Addendum No. 1

RE: Contract # C204173

1 Section of US-21, 1 Section of US-29, 1 Section of NC-16

May 15, 2018 Letting

STATE	PROJECT NO.	SHEET NO.	TOTAL SHEETS
N.C.		3	
WBS NO. 2018CPT.10.11.10601.1, etc.

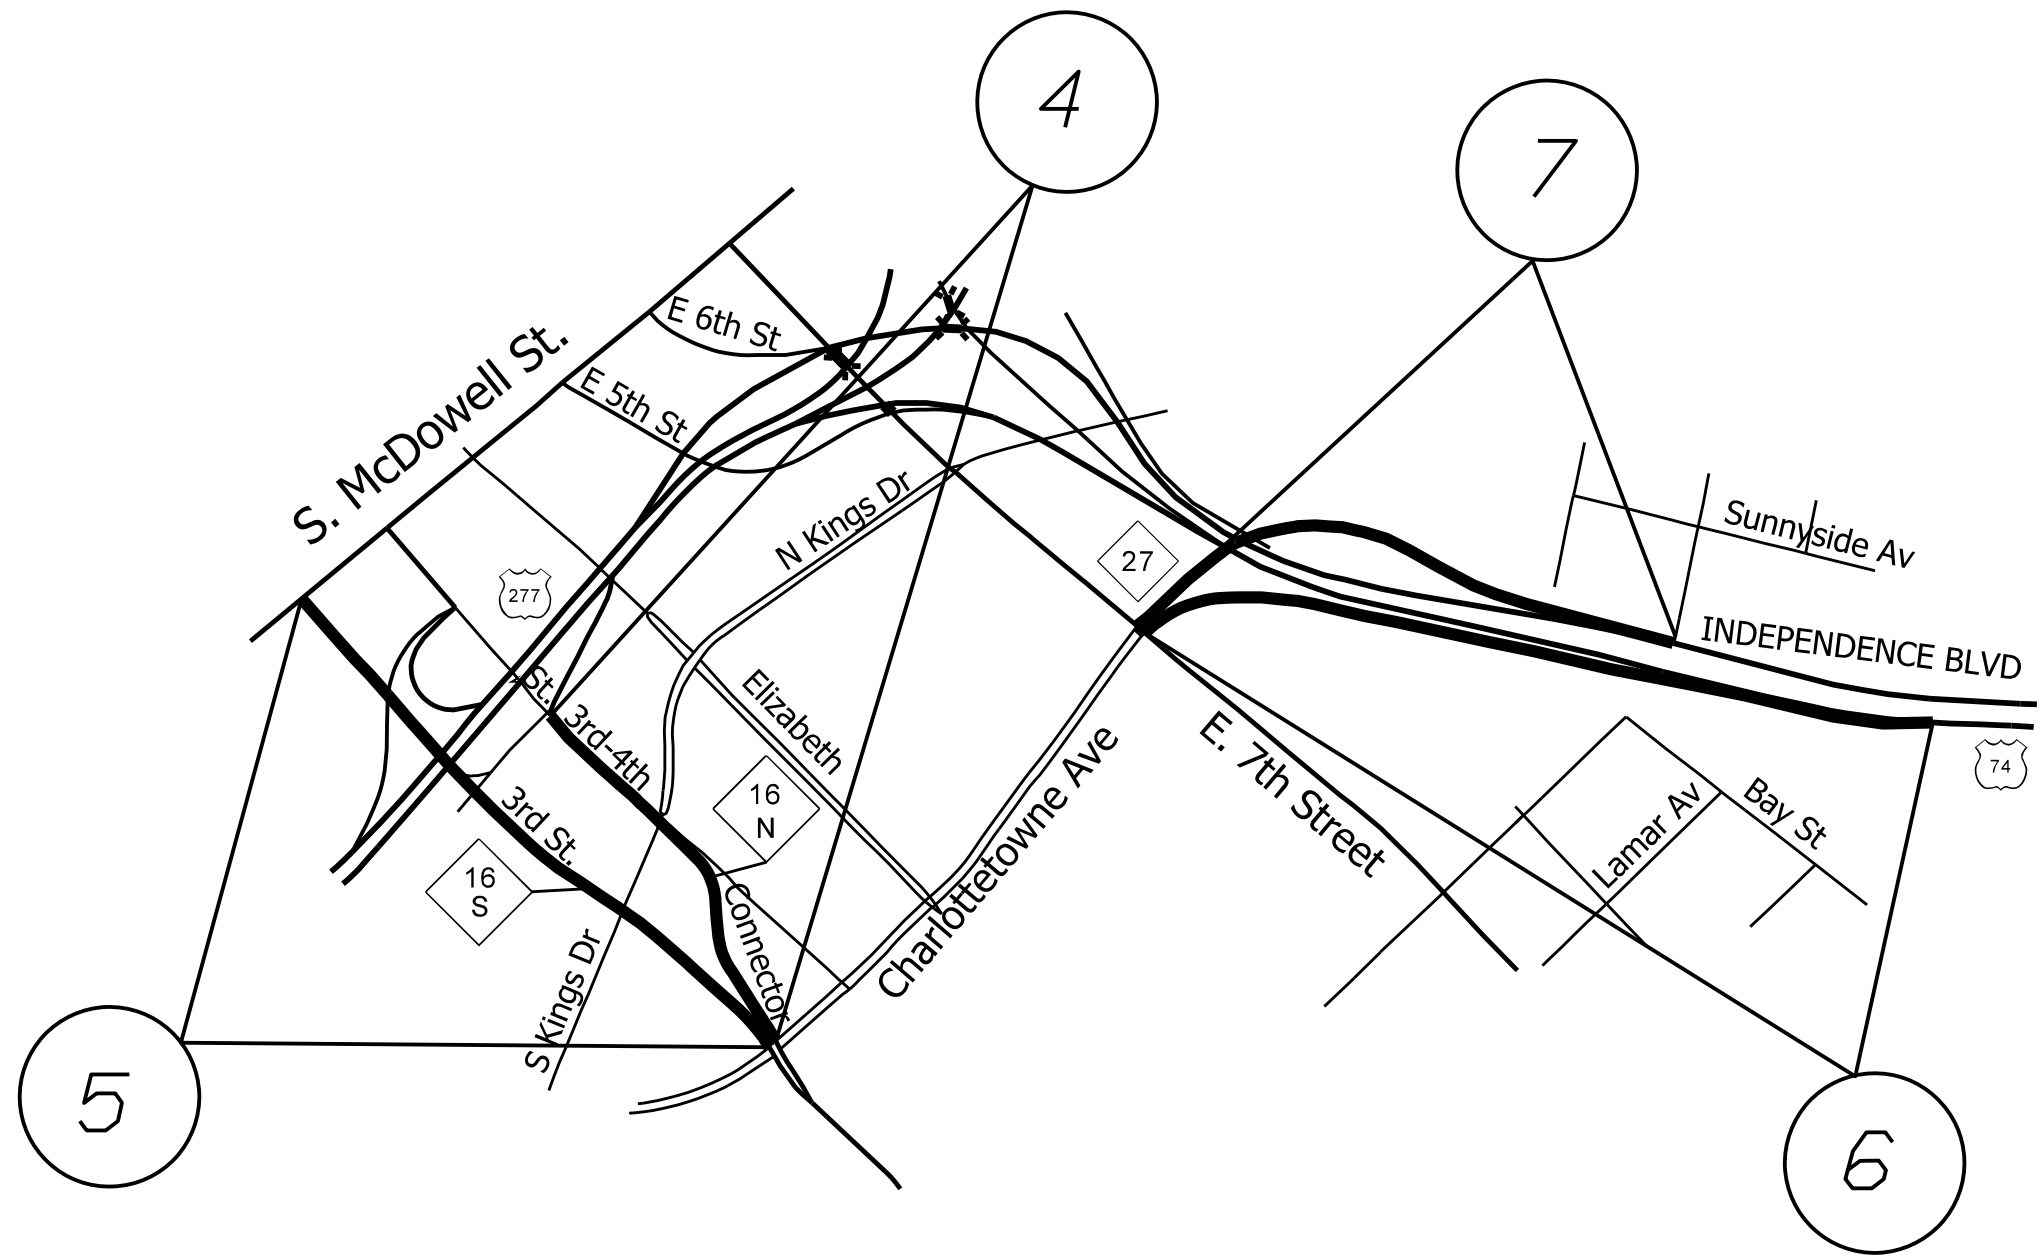
In addition, the Contractor shall not close or narrow a lane of traffic on **Maps #4 thru #7**, detain and/or alter the traffic flow on or during special events, as follows:

9. For any event at **Bank of America Stadium**, between **three (3)** hours before the start and **three (3)** hours after the end of the **Event**.
10. For any event at the **Spectrum Center**, between **three (3)** hours before the start and **three (3)** hours after the end of the **Event**.
11. For any event at the **BB&T Ballpark**, between **three (3)** hours before the start and **three (3)** hours after the end of the **Event**.

In addition, the Contractor shall not close or narrow a lane of traffic on **Maps #6 & #7**, detain and/or alter the traffic flow on or during special events, as follows:

12. For any event at the **Bojangles Coliseum/Ovens Auditorium**, between **three (3)** hours before the start and **three (3)** hours after the end of the **Event**.
